From: [REDACTED]
Sent: 12 December 2024 14:53
To: Planning
Subject: Planning Application No: 3/2221/0275 Land behind the Dog Inn

Response to the above planning application [REDACTED]

Site Section through The Dog Inn, Plot 2 and 36 Darwen Close

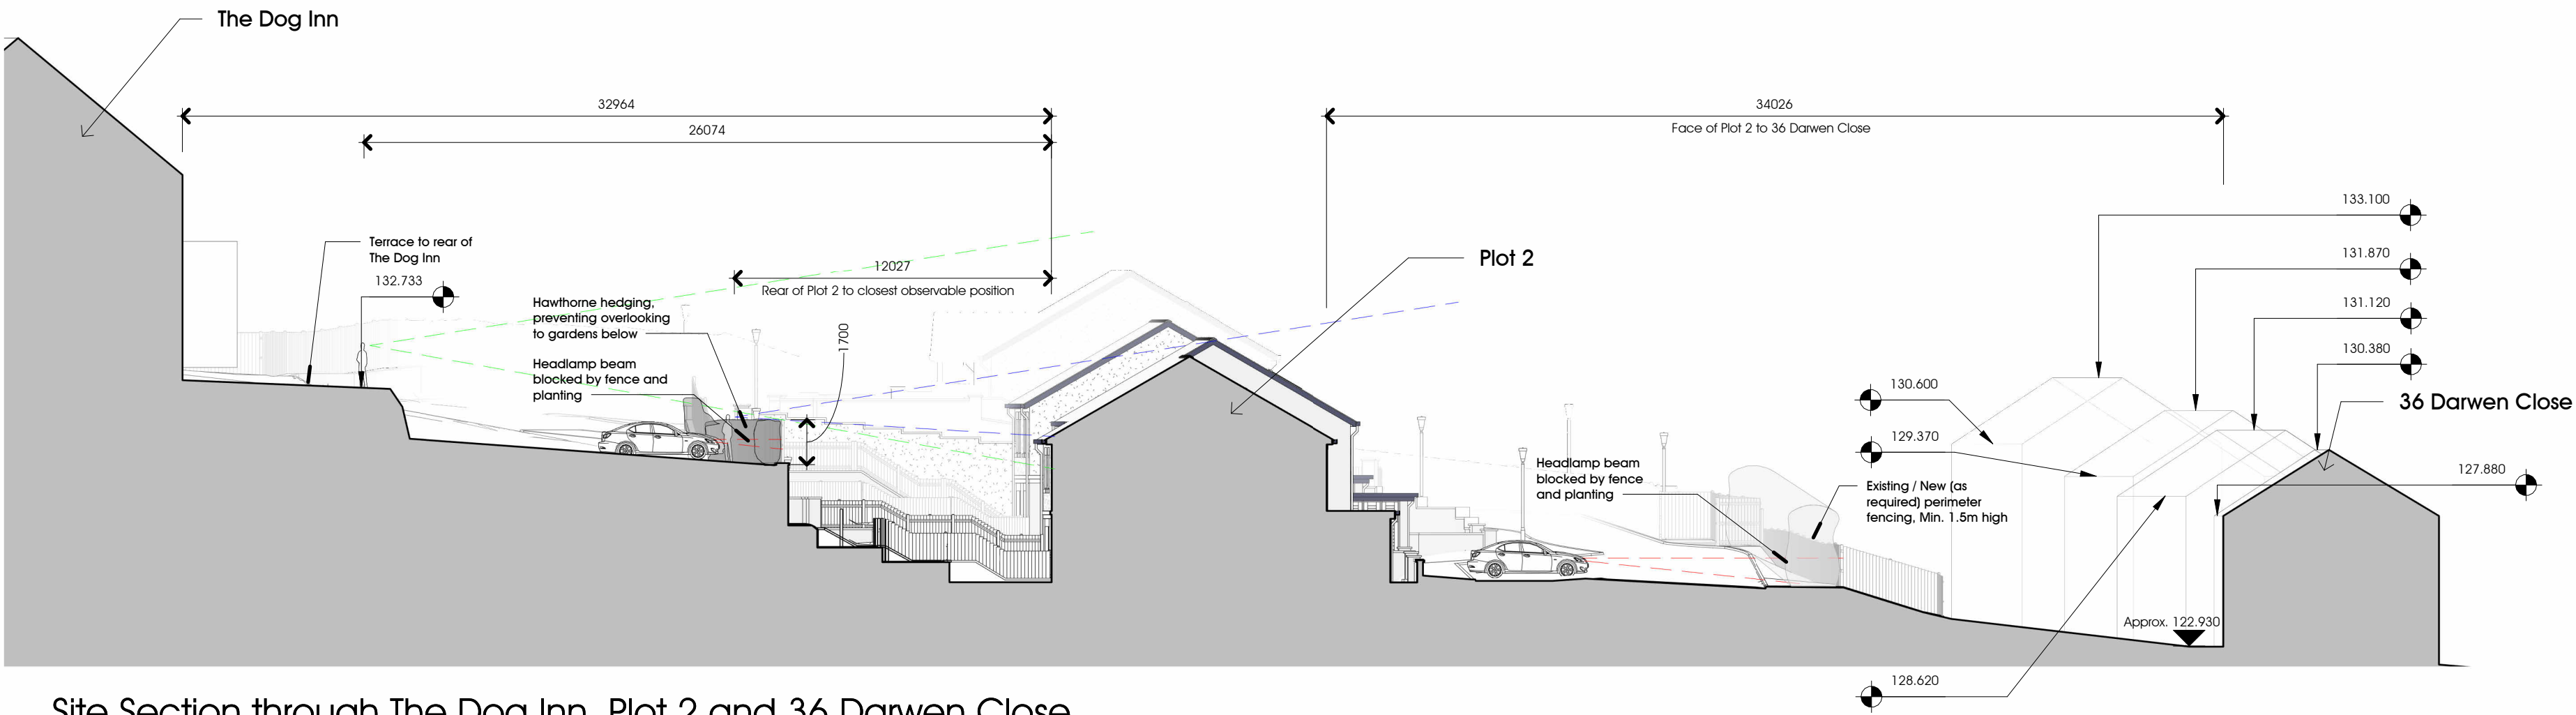
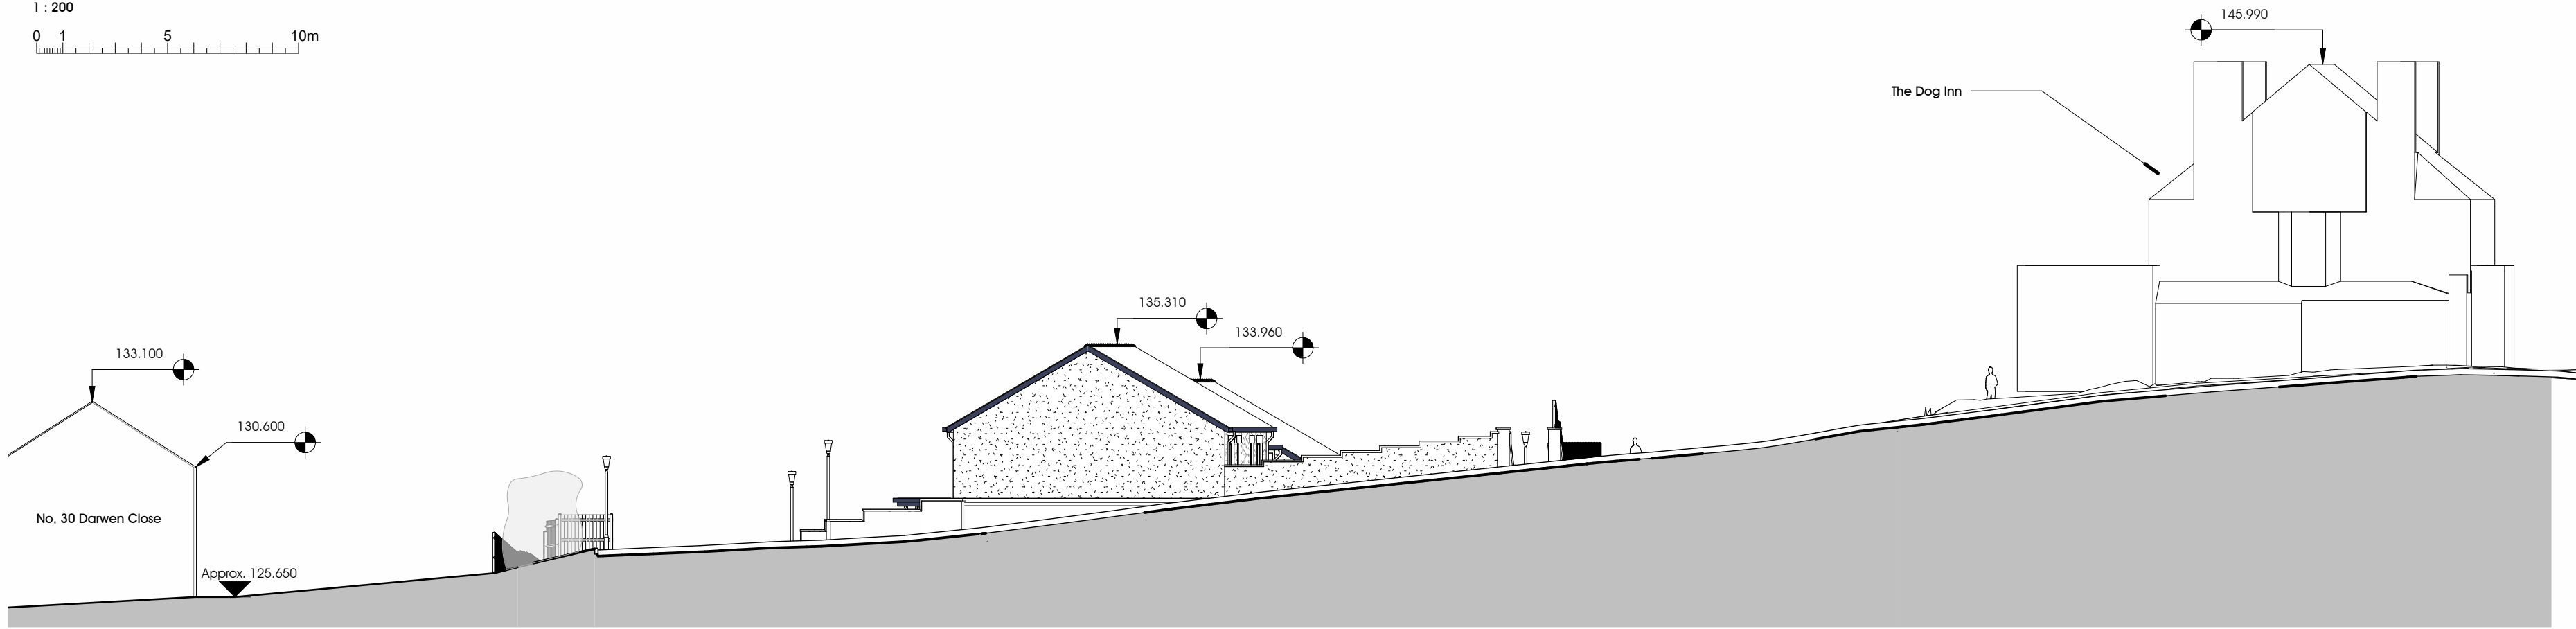
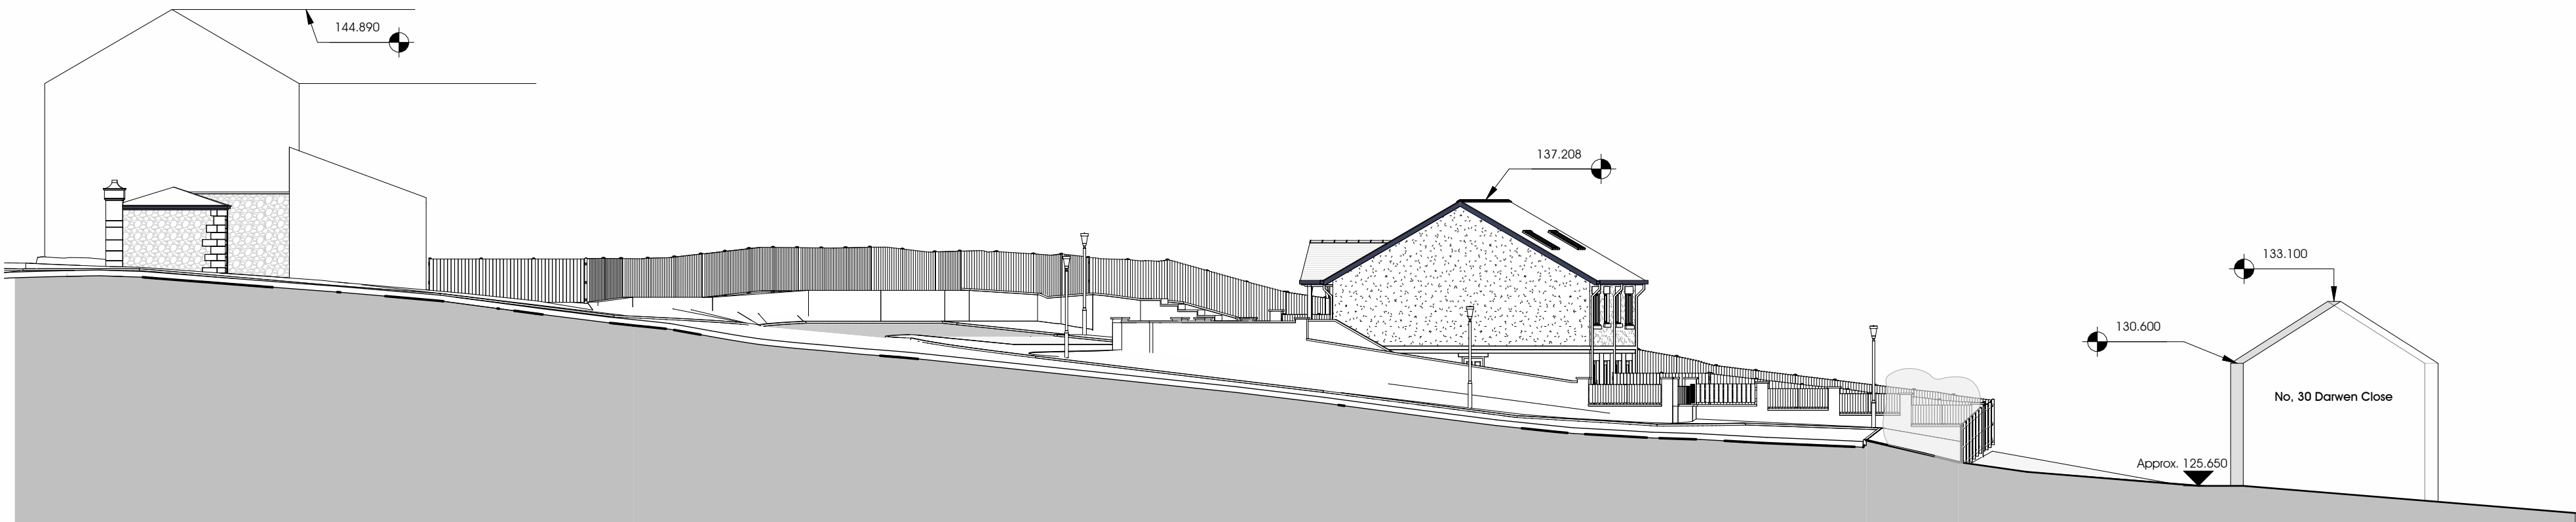
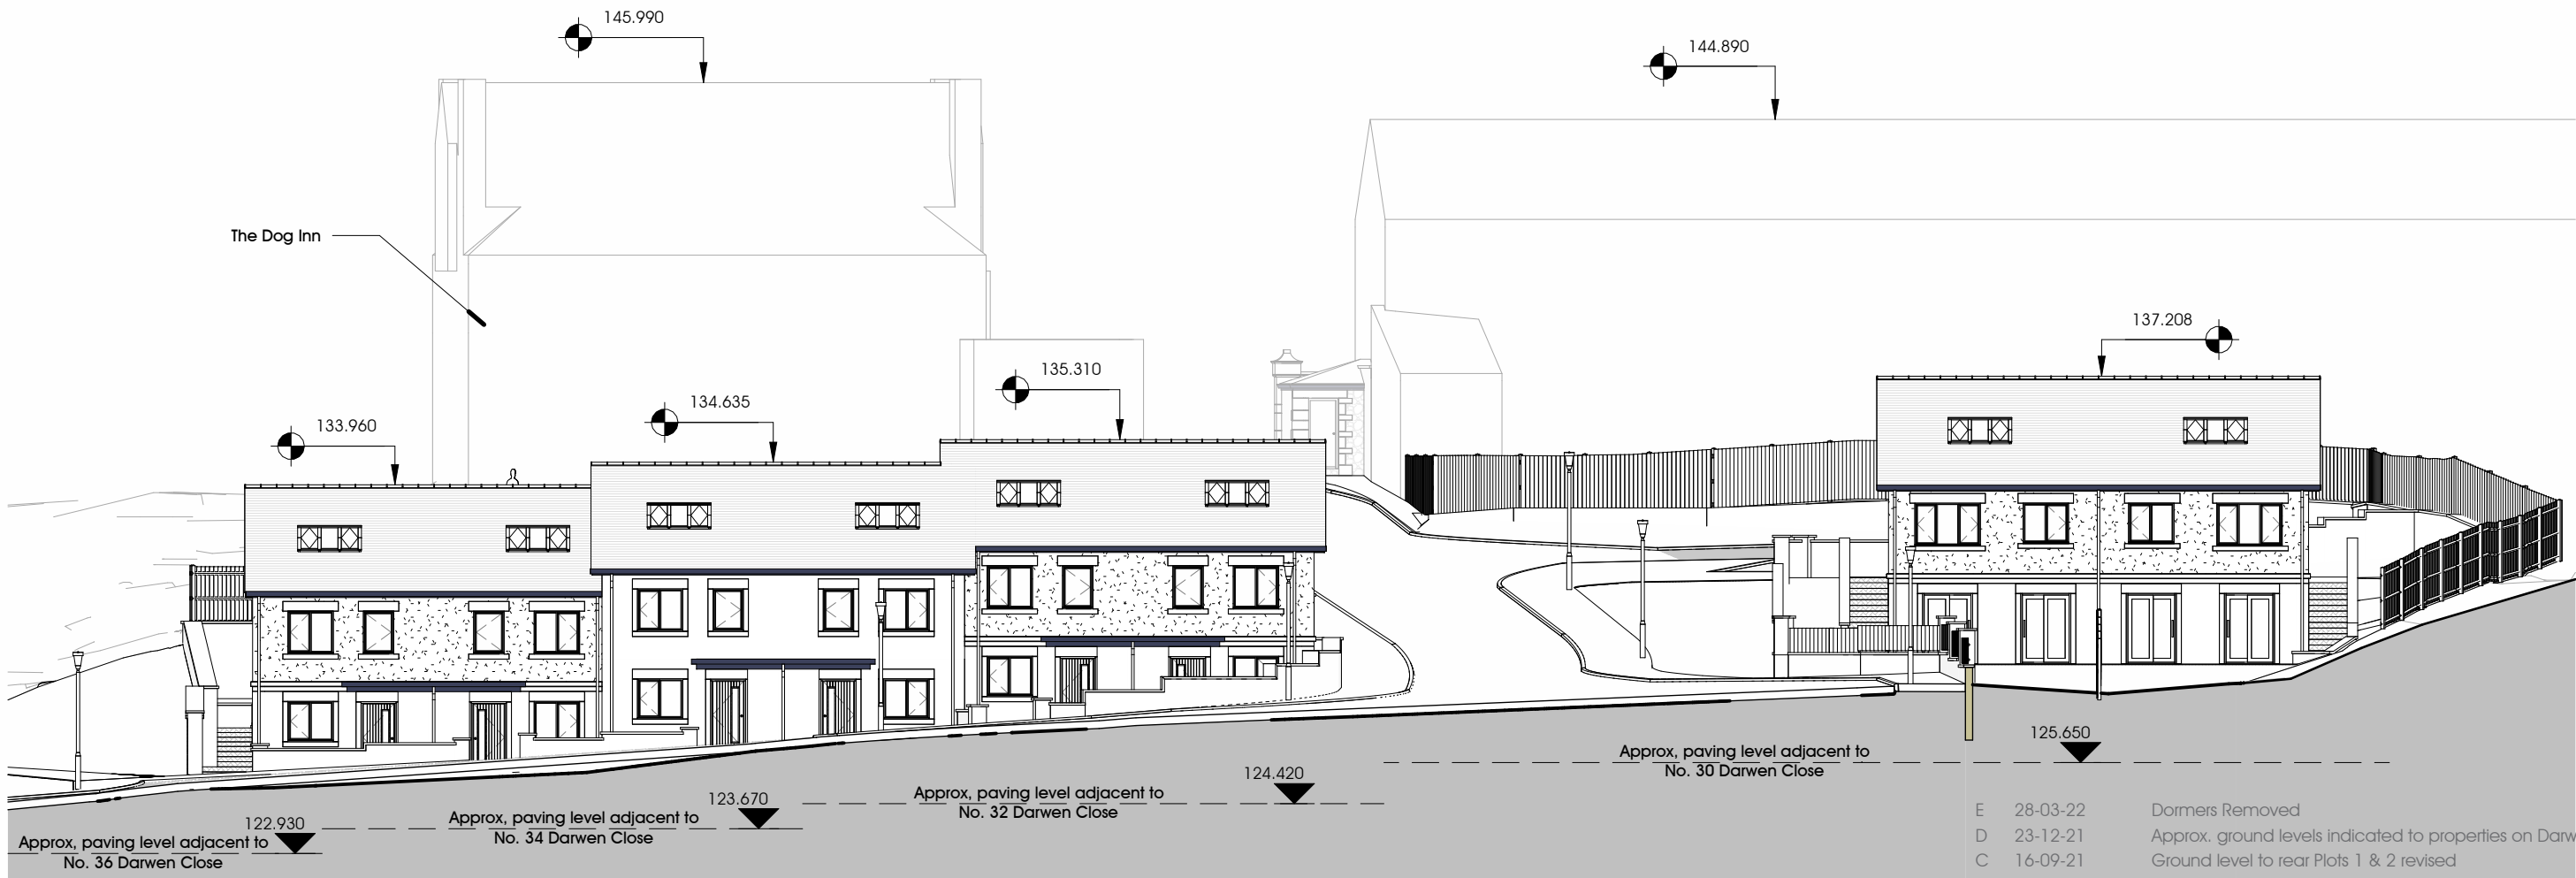
Although plots 3 & 4 are [REDACTED], we feel the height of the buildings will [REDACTED]. Due to the sloping nature of the site plot 4 will be built higher than ground level which will make the development [REDACTED].

We still feel that plots 1 to 4 are very imposing due to the property height and the sloping nature of the site. We feel that single storey properties on this part of the development would be more appropriate.

Proposed Site Plan
1 : 200
0 1 5 10m

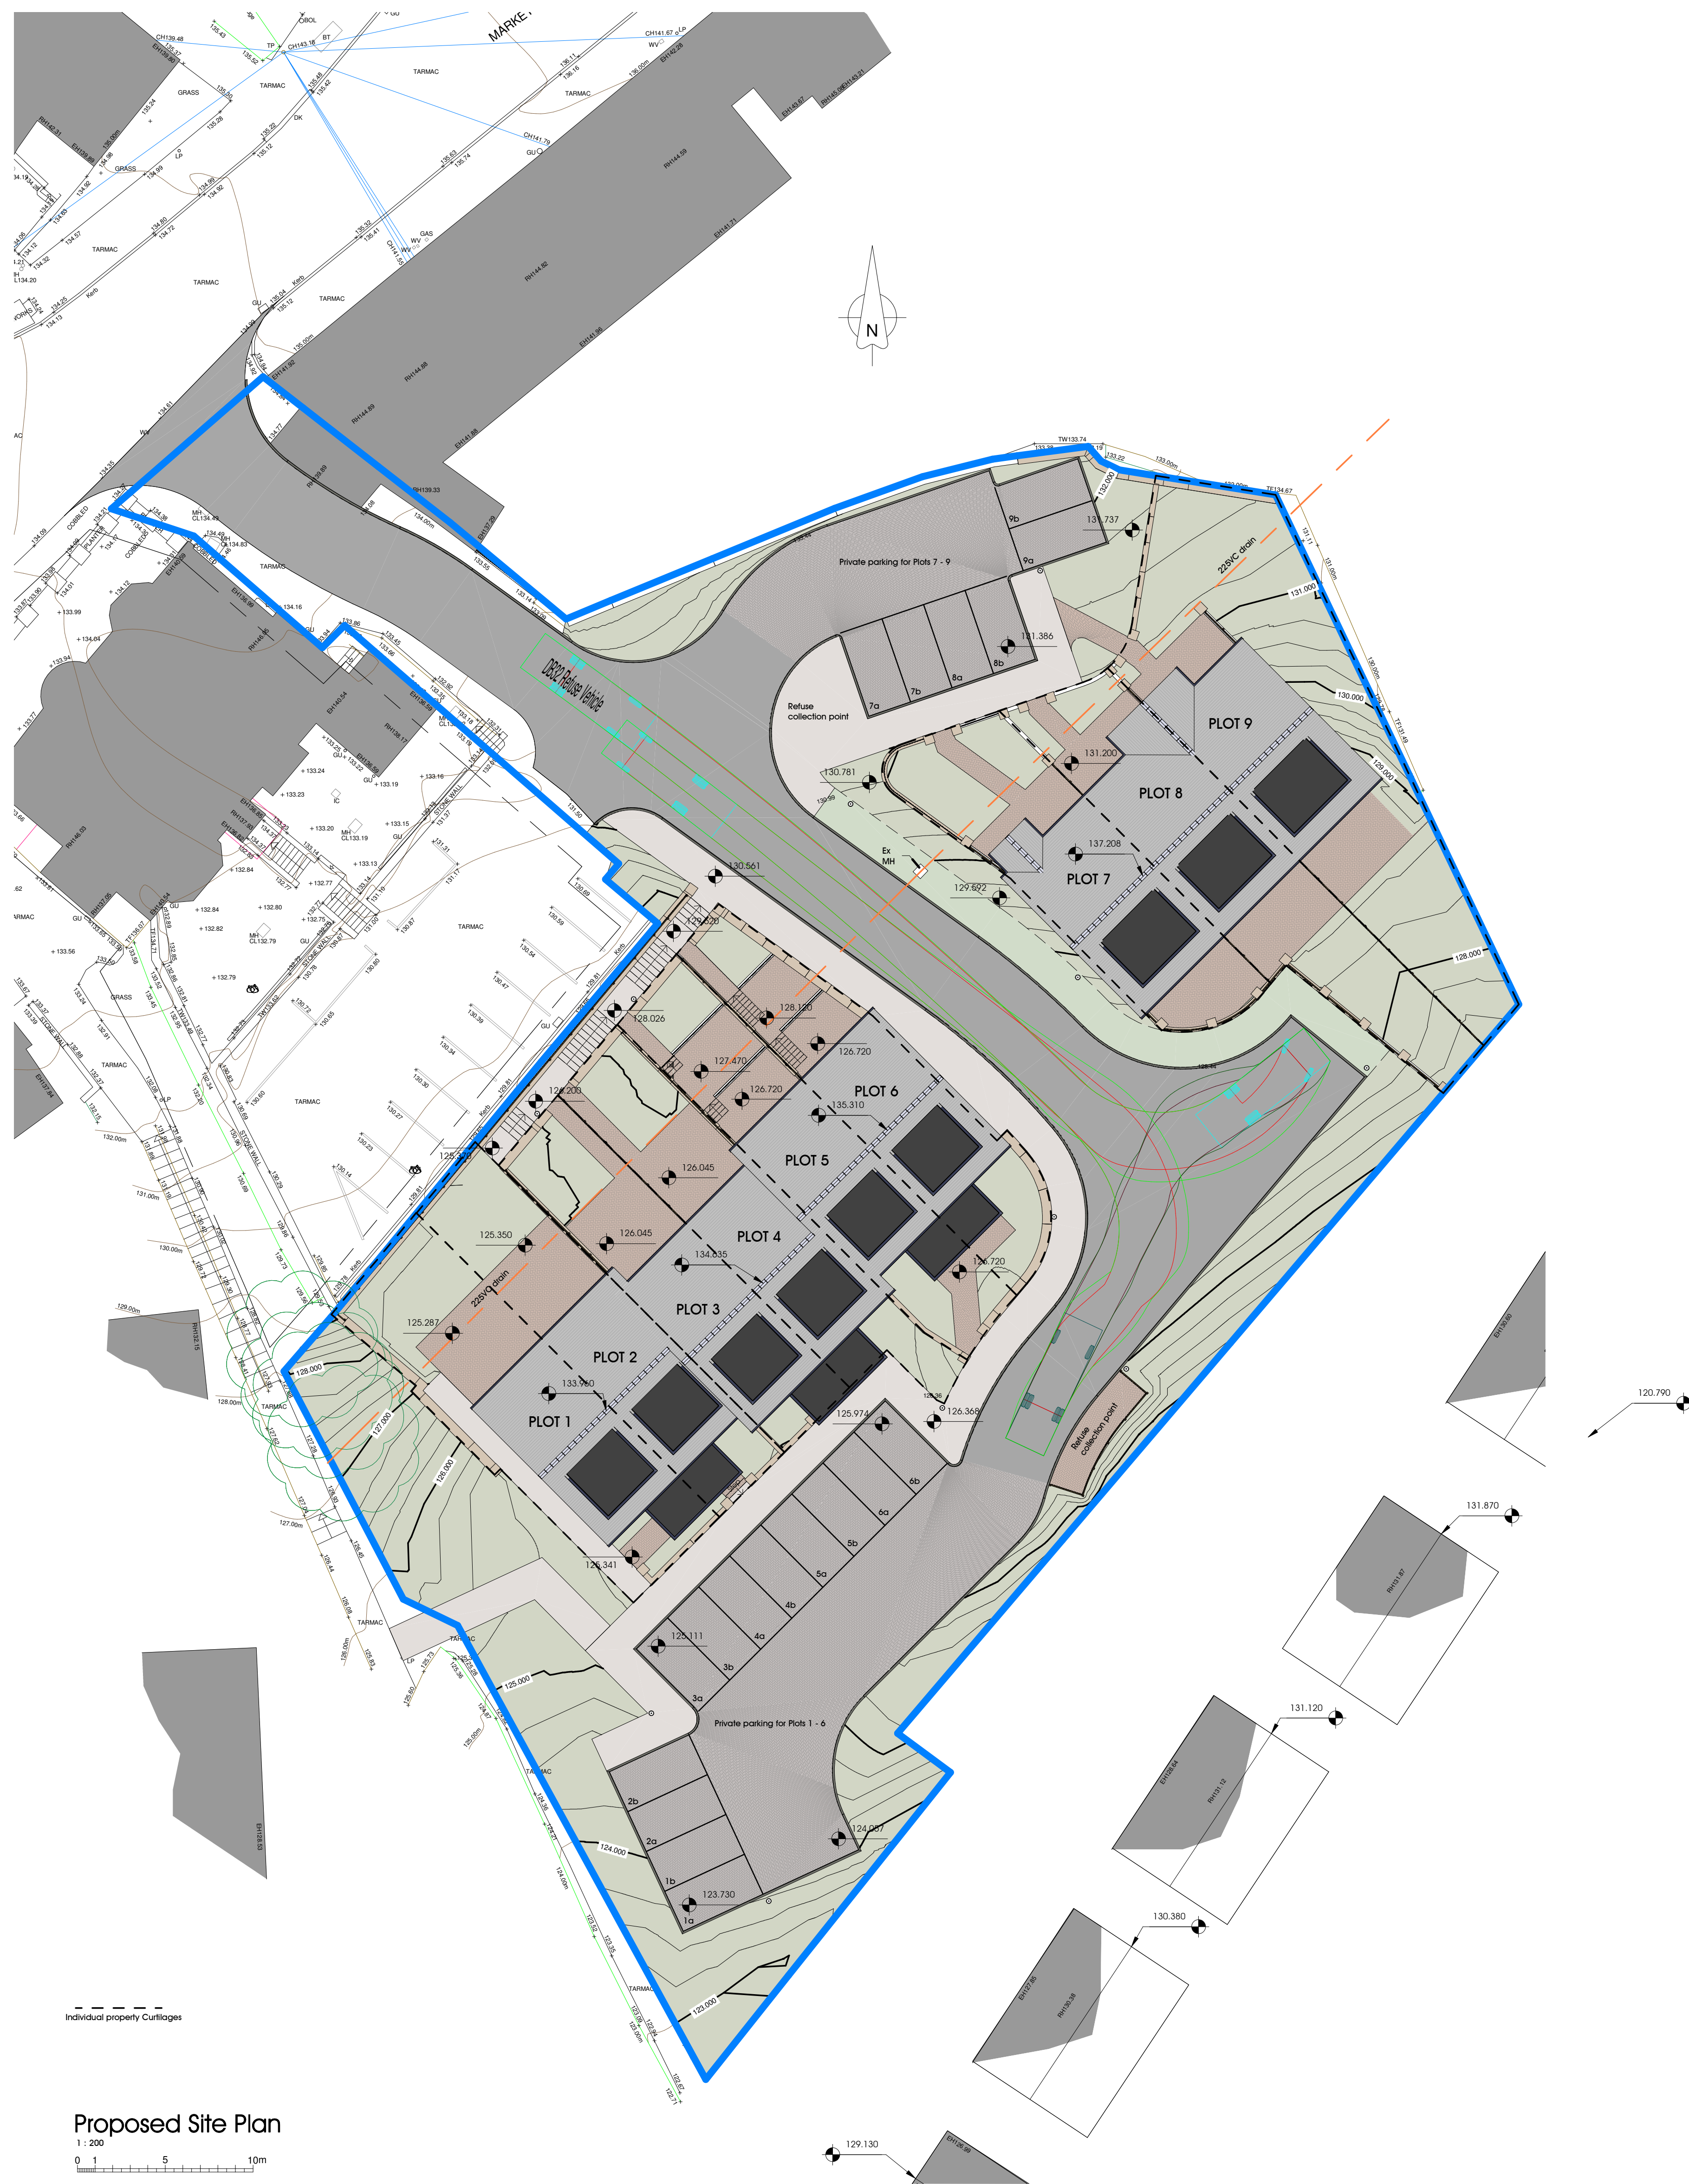
As we have previously stated the mass of hardcore already put down on the site [REDACTED] ground saturation. All the proposed hard landscaping will make the situation worse for all the adjoining properties on Darwen Close. We still have concerns regarding the drainage from plots 3 & 4 which [REDACTED] ground level. Although there is a proposed soakaway at 1.2 metres deep, this will at a higher level than the adjacent properties on Darwen Close and therefore any water will soakaway into their land.

The G3 hedging should be retained as stated on plan. It is imperative that the tree roots are protected. The plans are still not clear regarding the fencing along the eastern boundary [REDACTED]. This must be a substantial height for security and privacy.

If the development goes ahead, we are concerned that the new road will be used for car parking for Dog Inn customers and staff which will be very detrimental with both noise and light pollution to the new property owners and the adjoining residents on Darwen Close.
